V2 - Drainage Report Review 1 Comments.pdf Markup Summary

DRAINAGE A PLAN & PROFILE

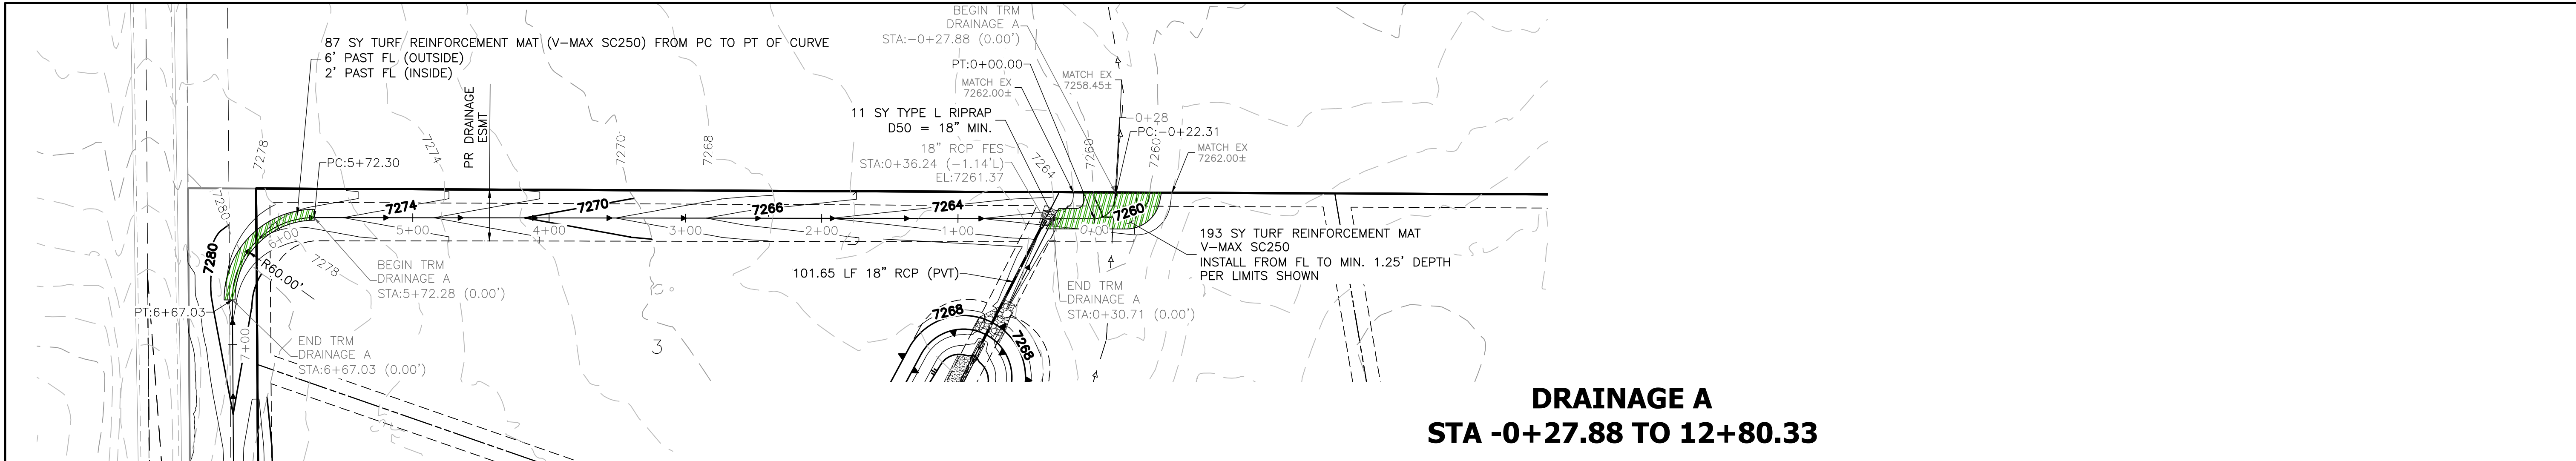
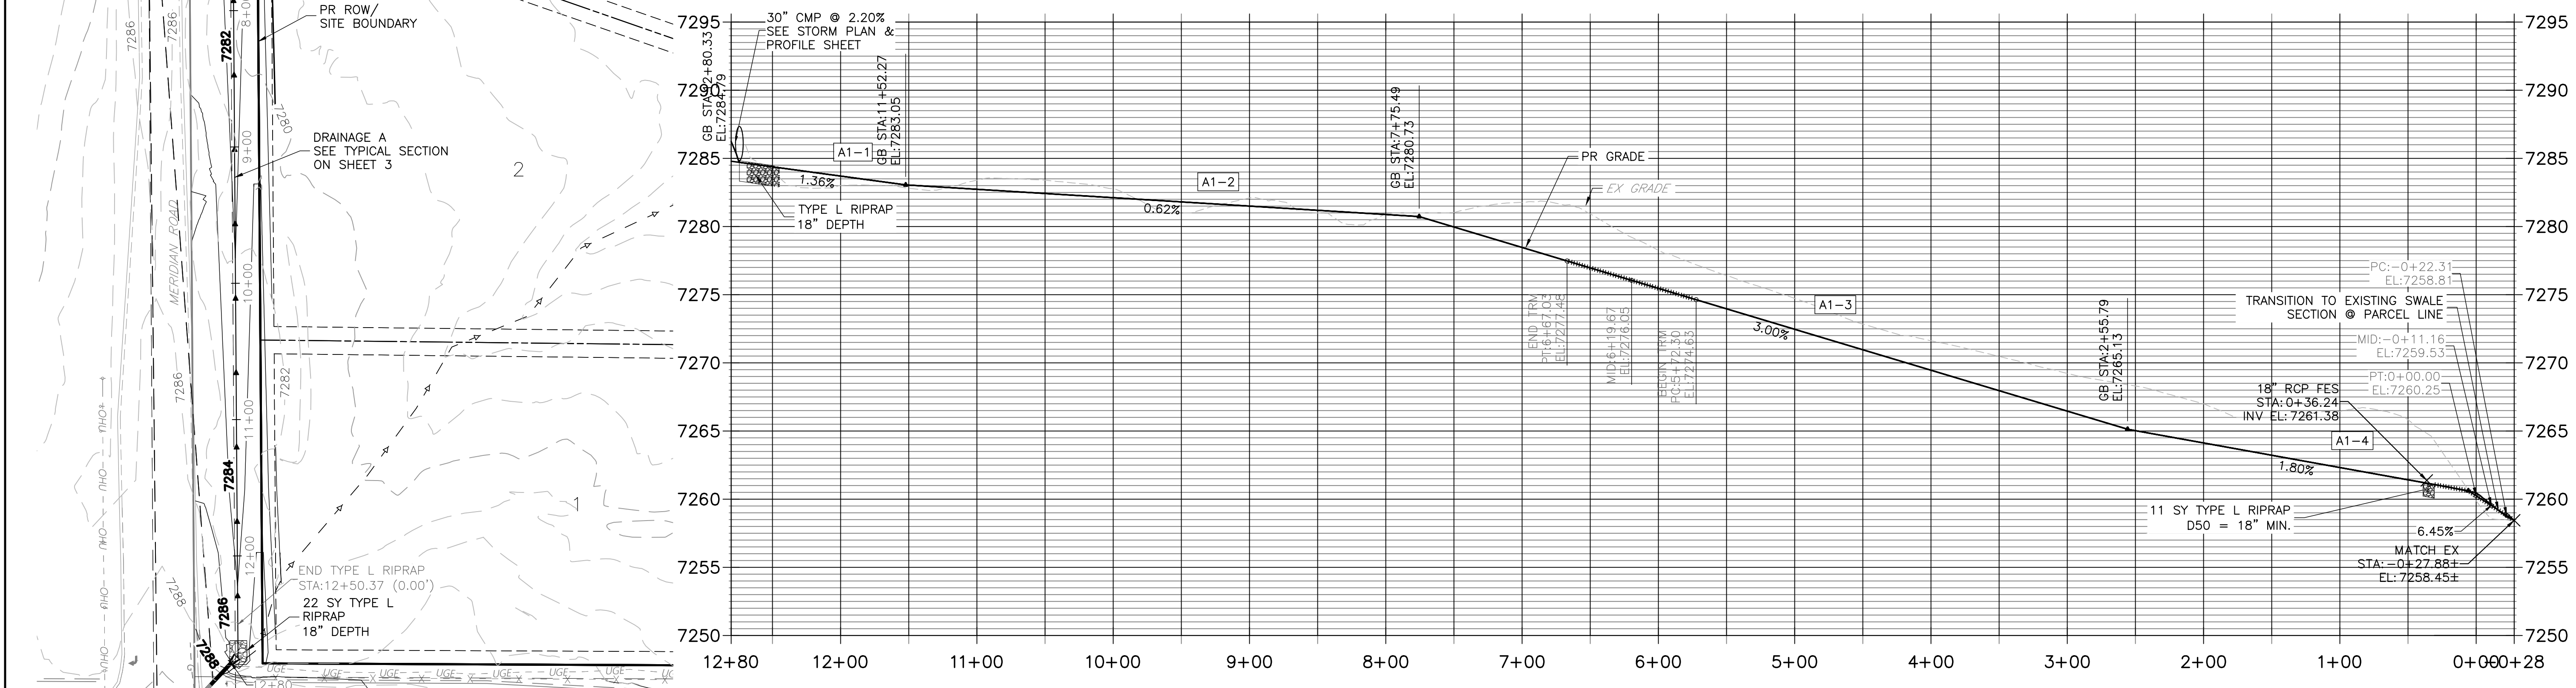
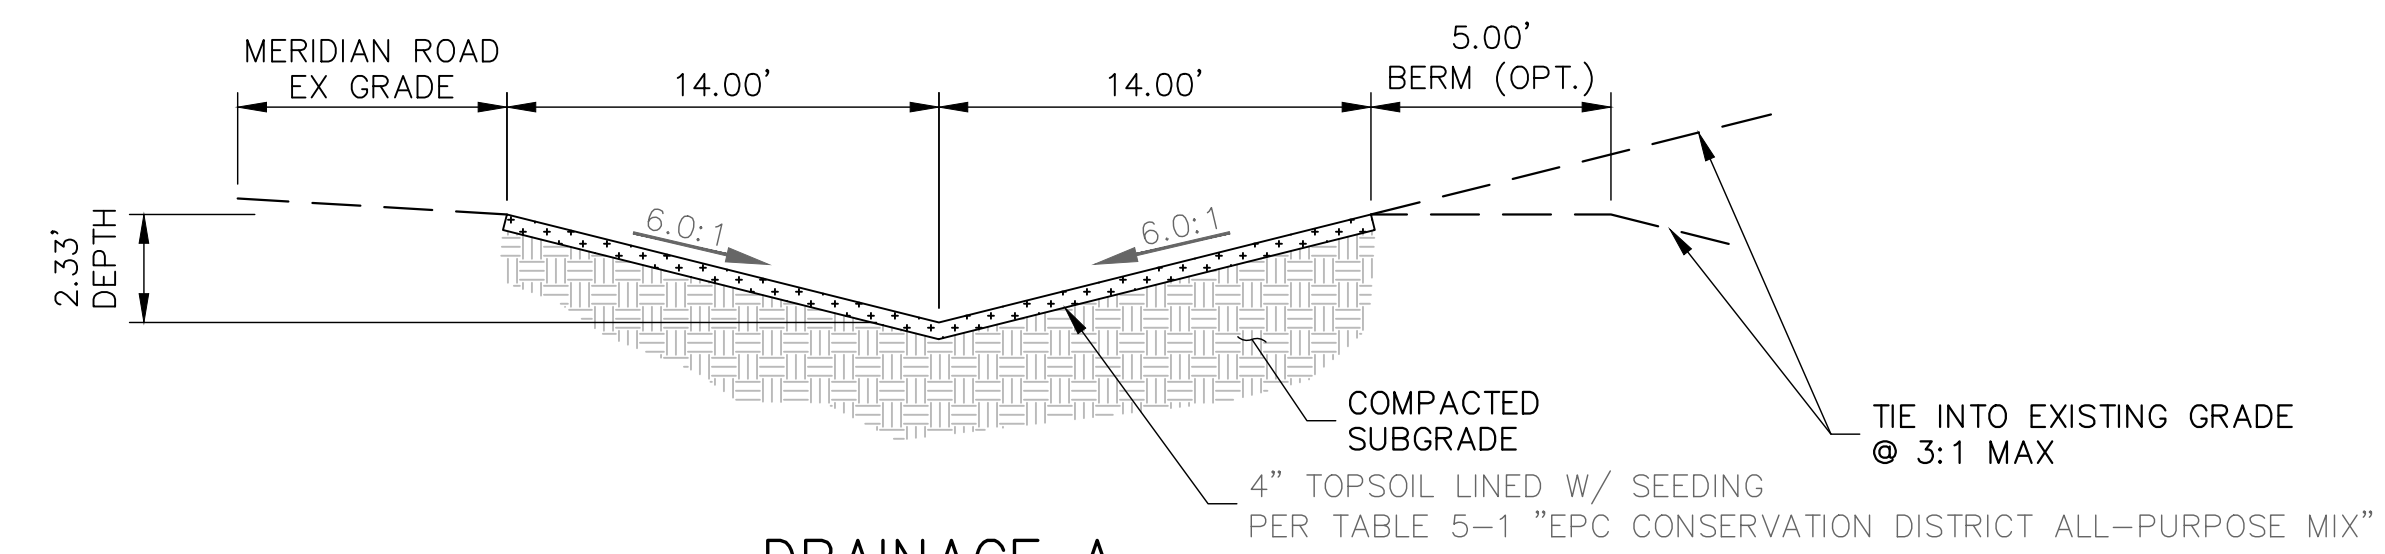
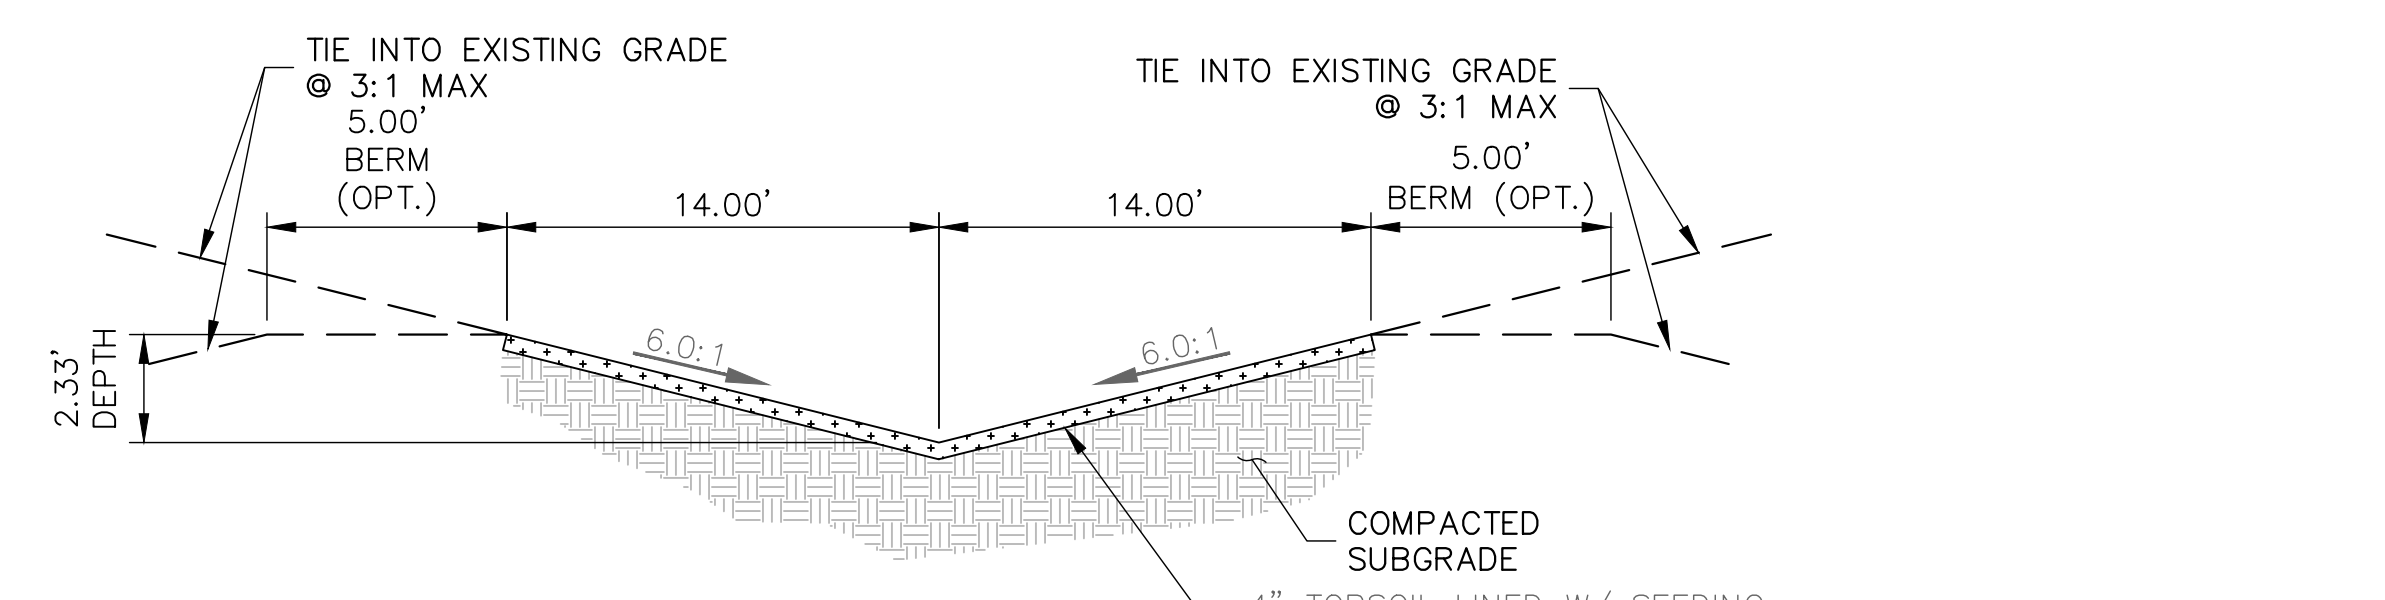
Please include velocities in the swale and discuss the 90 degree bend at the north end of the property and if this area requires any armoring.

please include grass type as max velocity is dependent on type.

please include velocities of the swale
